**KIRKLEES COUNCIL
TOWN AND COUNTRY PLANNING ACT 1990
HIGHWAYS DEVELOPMENT MANAGEMENT**

PLANNING REF 2018/62/94181/W0/CC
CATEGORY Small Major

PROPOSAL ALTERATIONS TO CONVERT
HOTEL (C1) TO 12 STUDENT
STUDIOS (WITHIN A
CONSERVATION AREA)

LOCATION 31-37, BEAST MARKET & 1,
SOUTHGATE, HUDDERSFIELD,
HD1 1QF

SECOND FLOOR PLAN – as proposed

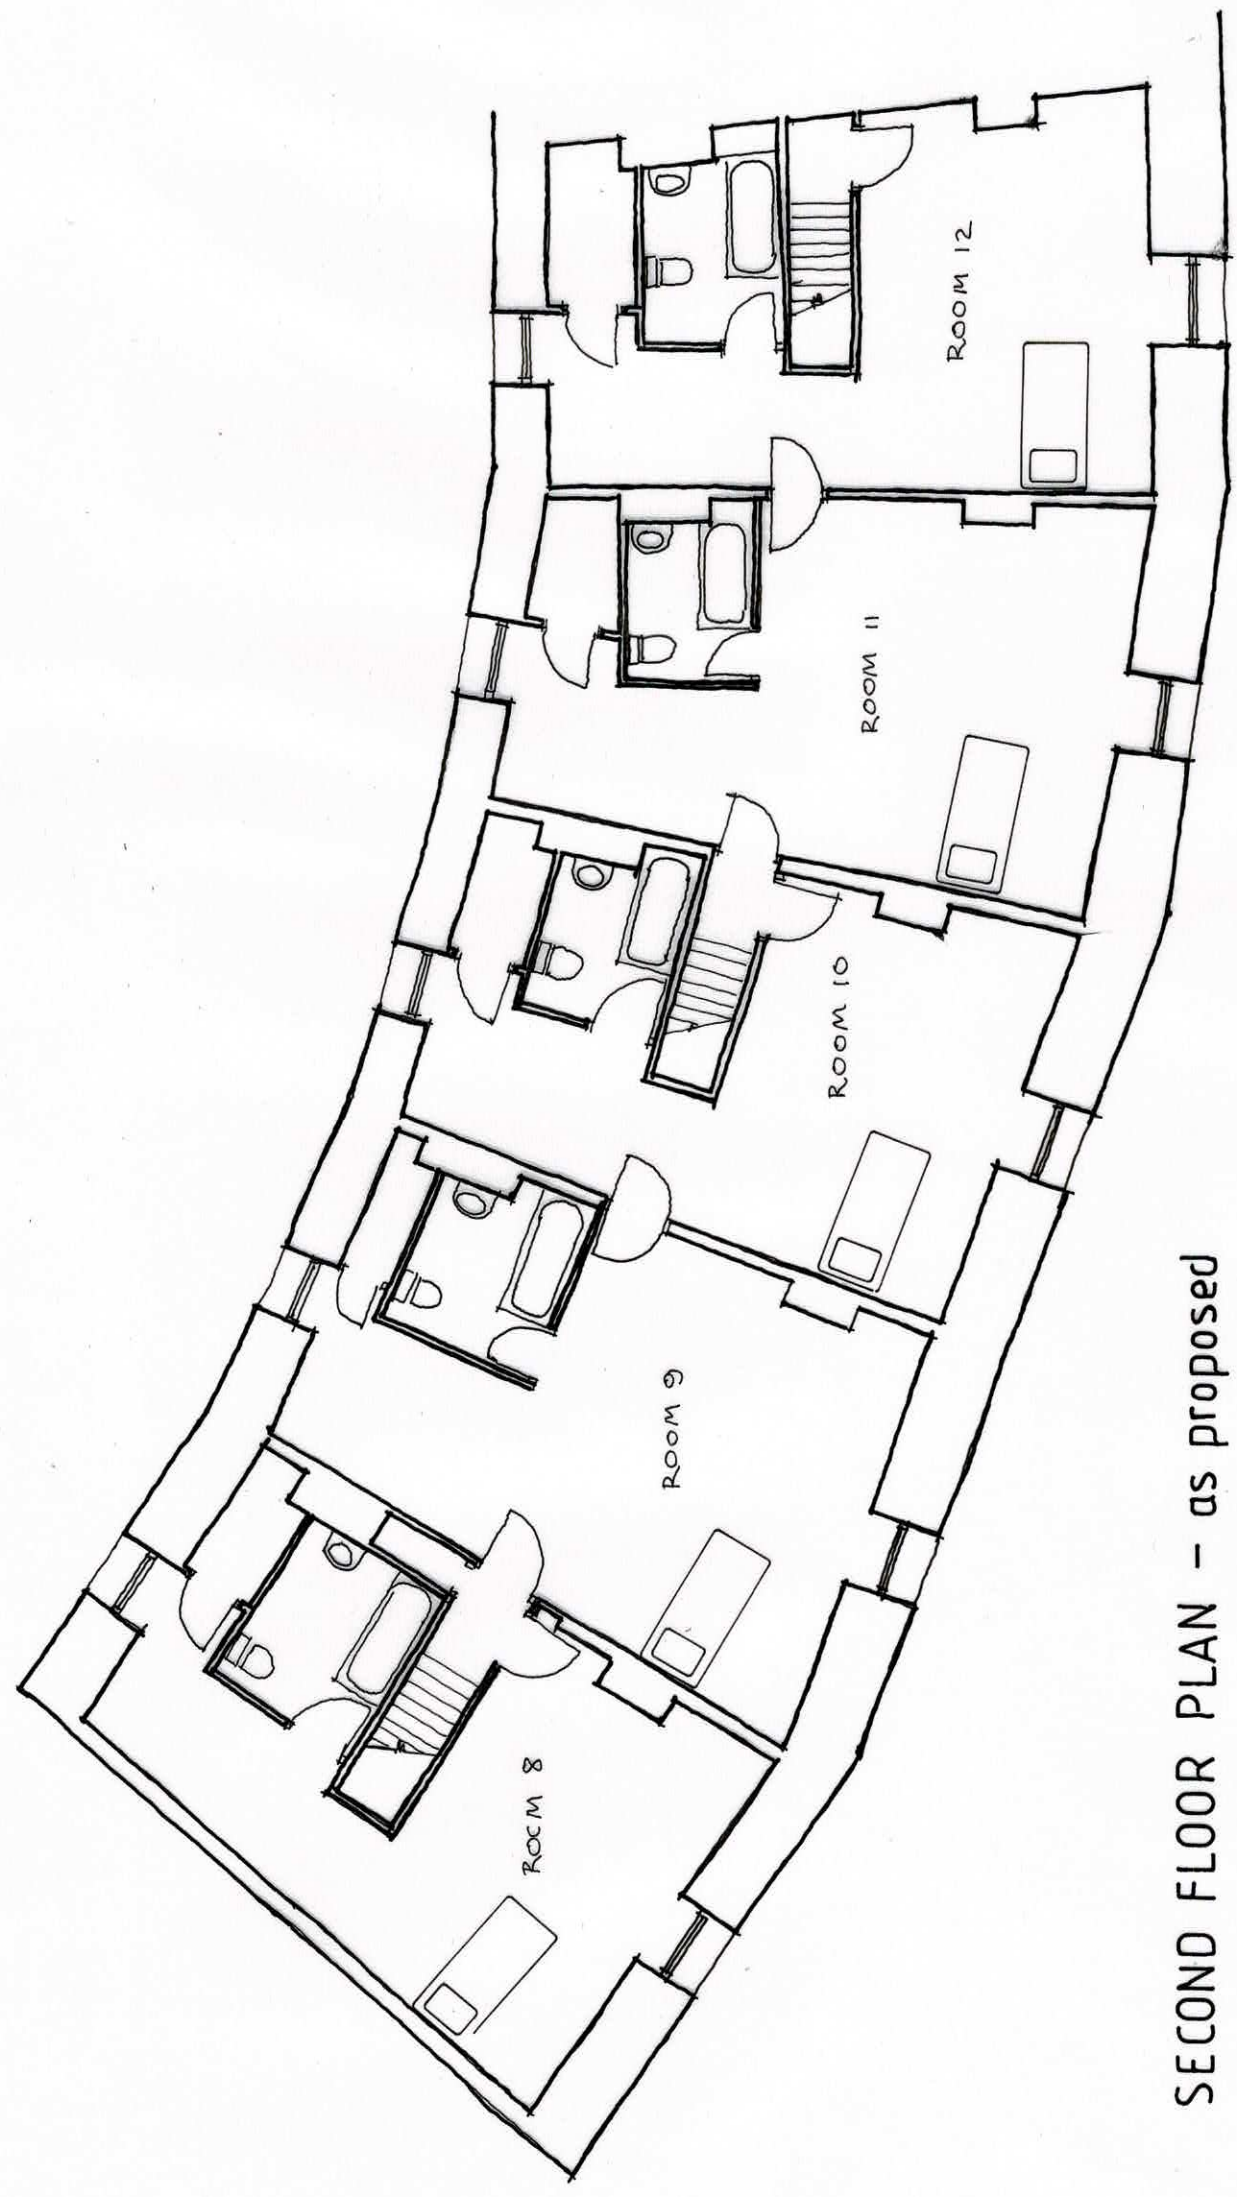
The plans show a total of 12 units plus one bedroom in the existing residential property at 1 Southgate, however a number of units appear to show two beds, giving a total of 17 beds (plus the bedroom in the existing dwelling). Although this will not have an impact on the day to day running of the student residences due to the sustainable location, it may have an impact on drop off/pick up days at the start and finish of term.

Due to this possible demand outstripping parking provision we would request that the applicant produces a car parking management plan that will indicate how parking will be managed on a day to day basis (allocation, users etc) and also how the additional drop off/pick up demand will be managed at term start/end times. If you are minded for approval we would request that this is added as a condition to any planning permission you may grant and suggested wording is provided below. If the applicant can provide suitable details prior to determination we would be happy to see the condition

No development shall take place until a Car Park Management Plan has been submitted to and approved in writing by the Local Planning Authority. The Car Park Management Plan shall include details of the types of users to be allowed to use the parking on a day to day basis and how this will be monitored and enforced, including the use of permits, and the proposed management of the parking spaces to be used for the drop off and pick up of students and their belongings at the start and end of term/academic year. This approved Car Park Management Plan shall be implemented before the accommodation hereby approved is first brought into use, and shall thereafter be retained.
